From: Dusty Pilkington
Sent: Wednesday, May 17, 2017 11:14 AM
To: Dan Carlson
Subject: FW: LP-17-00004 MDJ Currier Heights Comments - Insufficient Information For City of Ellensburg Community Development Review At This Time
Attachments: 5-15-17 Letter from County Public Works - Insufficient Information for Review At This Time.pdf
Importance: High

TO: Ms. Kelly Bacon, ET I
COPY: Lucas Huck, County Road Engineer
DATE: May 15, 2017
FROM: Mark R. Cook, Director 
RE: Currier Heights

Lacking any additional detail, the supplied plat drawing of Currier Heights is insufficient for Public Works to provide specific comments to Community Development. General comments concerning transportation and stormwater management are provided below for Community Development Services consideration.

SHEET CONTENTS
SITE PLAN

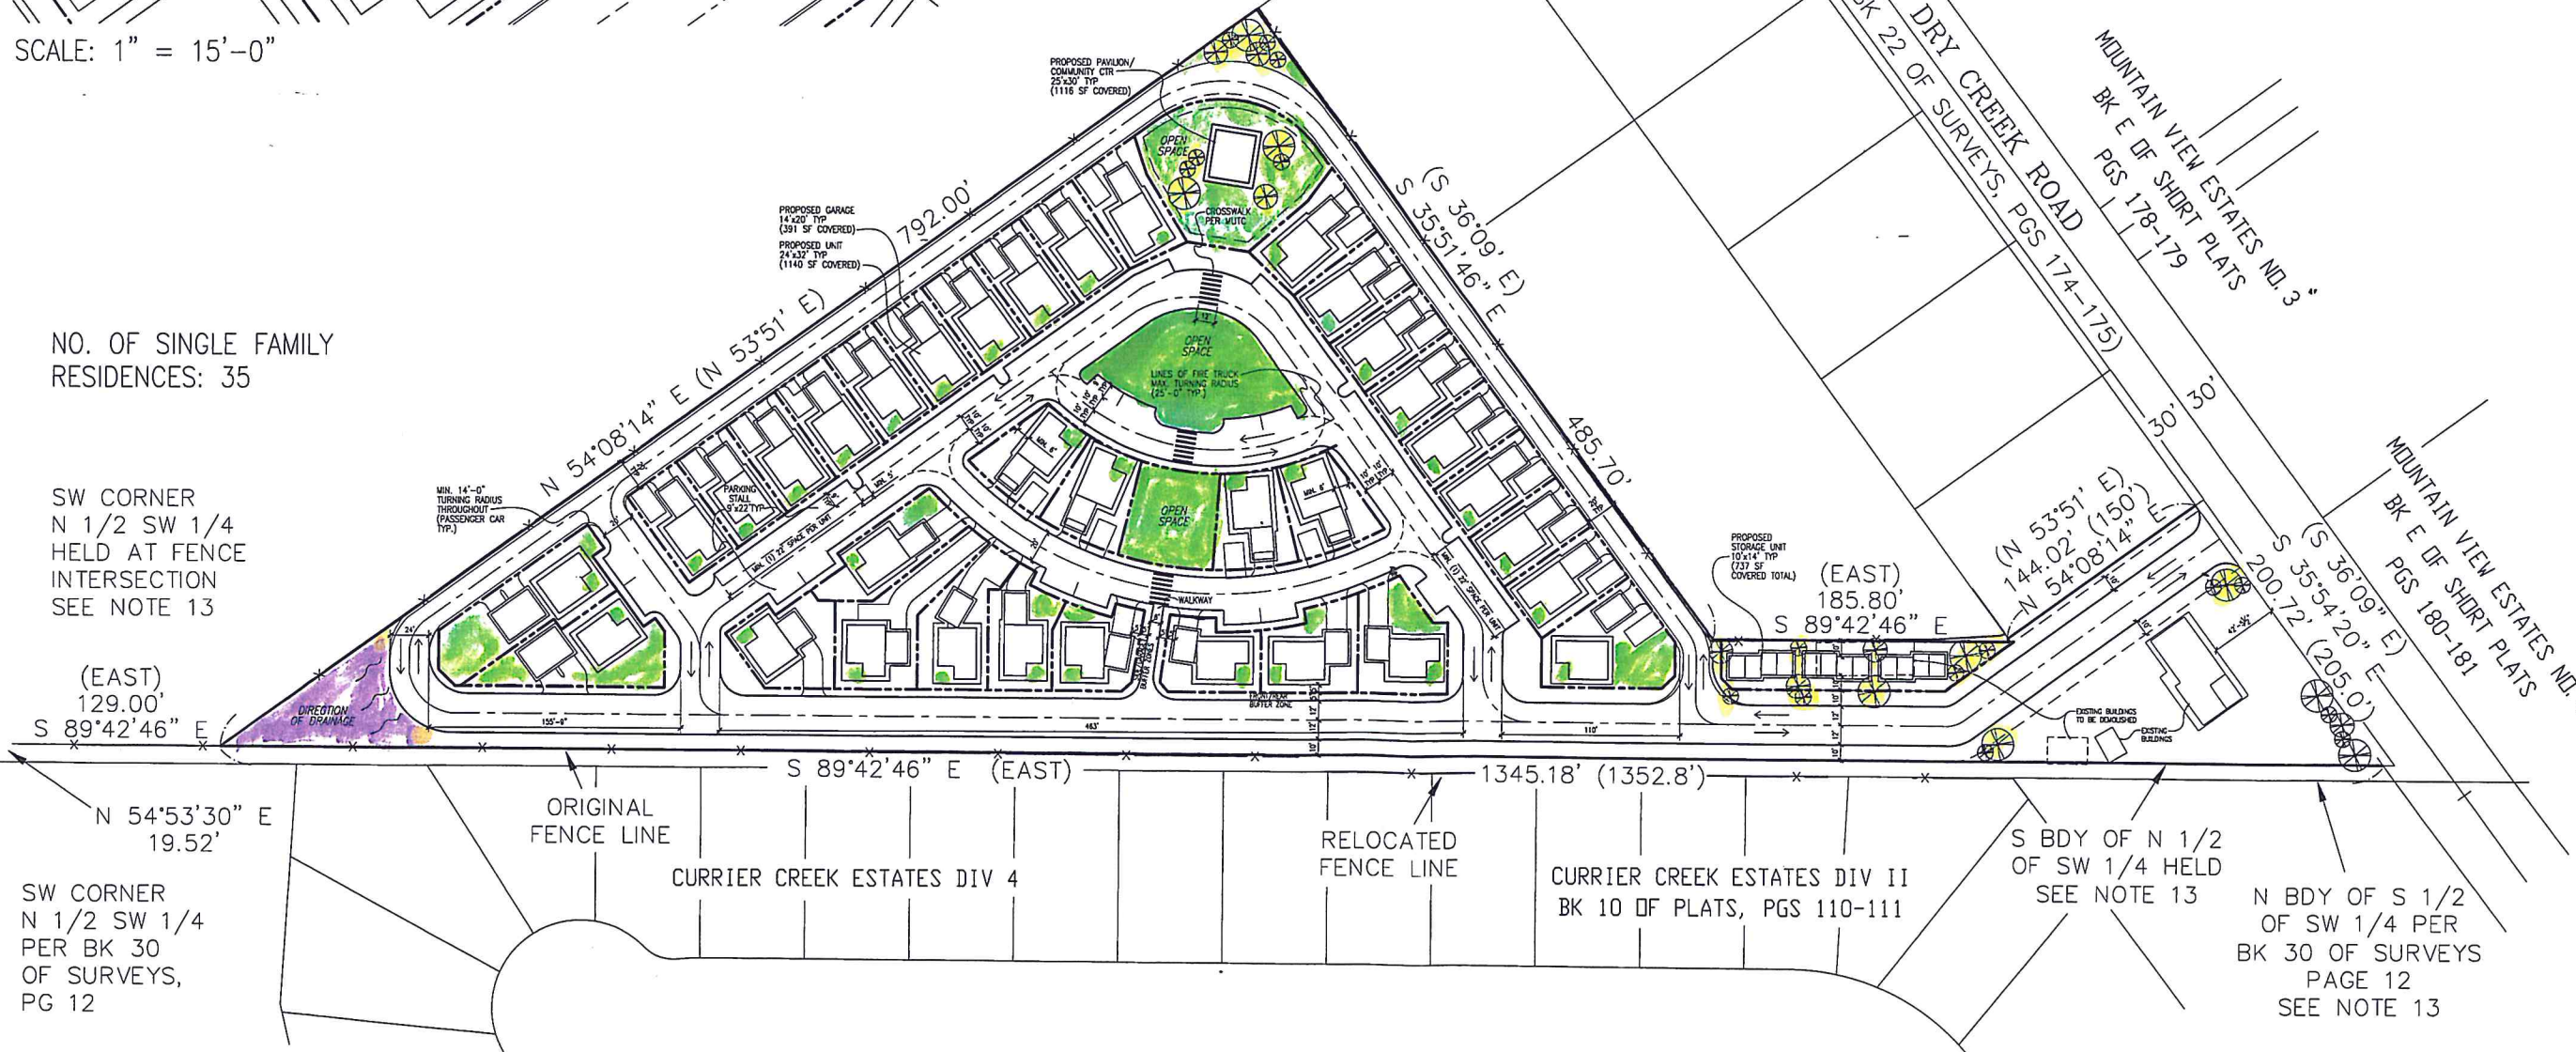
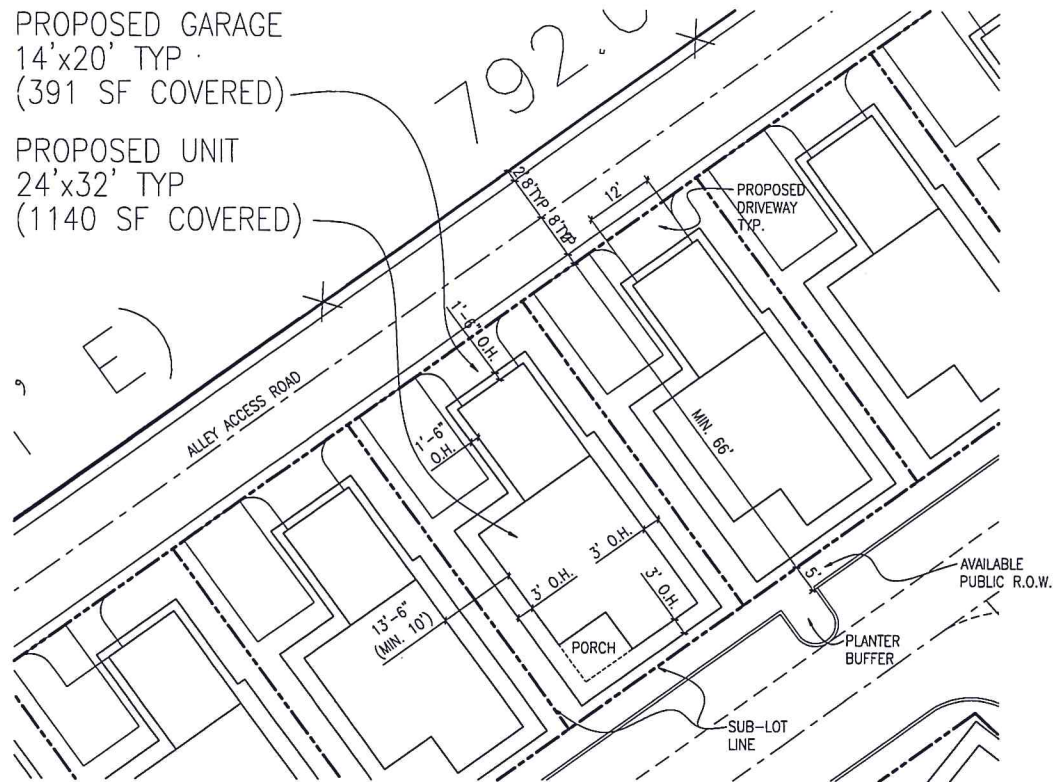
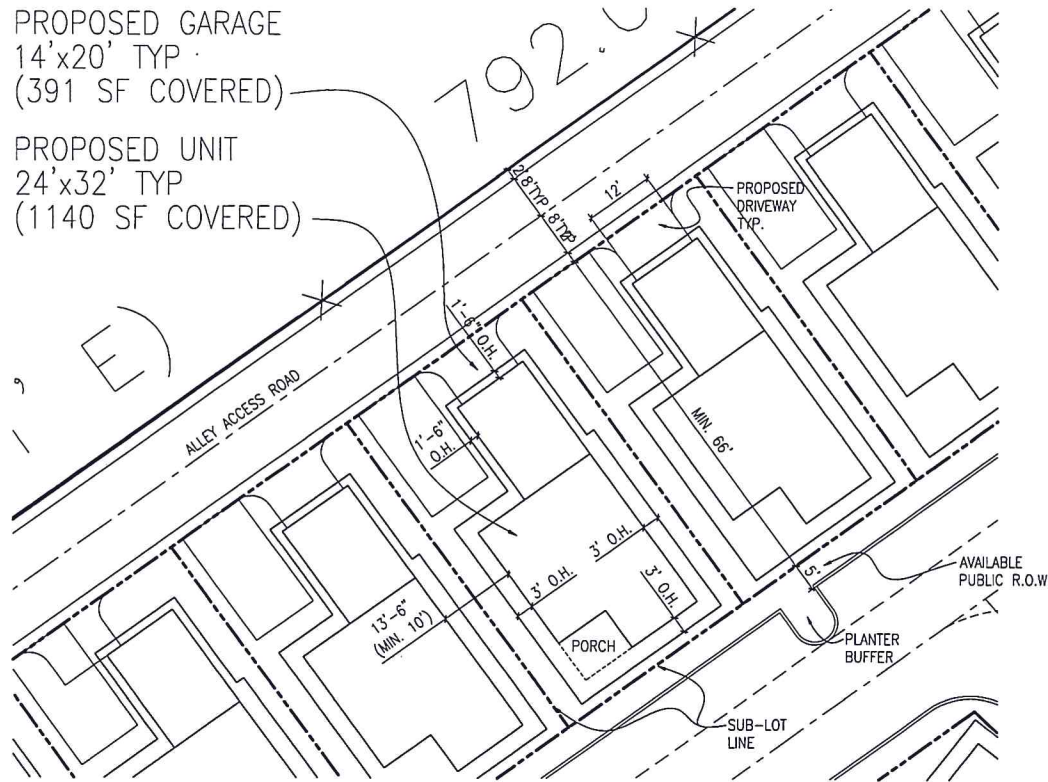
1. Kittitas County Code 12.04.040(b) (Design Criteria within an Urban Growth Area) affords final approval of the road alignment, geometry and construction requirements to the City of Ellensburg (Currier Heights). This same section references the "more stringent" of the County or City standards apply. Taken together, I interpret our code to mean the County's right of way requirements together with the wider of the two jurisdiction cross-sections with curb-gutter-sidewalk on all roadways. Given this requirement, the proposal provides far too little detail to comment further on the road proposal serving the plat. The submitted materials are insufficient for further staff review.

2. The plat is located in a known area of flooding. Two recently purchased homes in Currier Creek Estates proximate to this proposal have experienced flooding this past spring. The proposal is insufficient in detail allowing me to understand how runoff from the site will be mitigated. It is likely that no offsite discharge will be allowed from the site given known flooding in the area. The submitted materials are insufficient for further staff review.

3. I have been provided data suggesting that the site contains freshwater emergent wetlands. The provided plat map makes no notice of associated wetlands. The presence of potential wetlands further complicates the stormwater treatment and disposal scheme supporting plat development. The submitted materials are insufficient for further staff review.
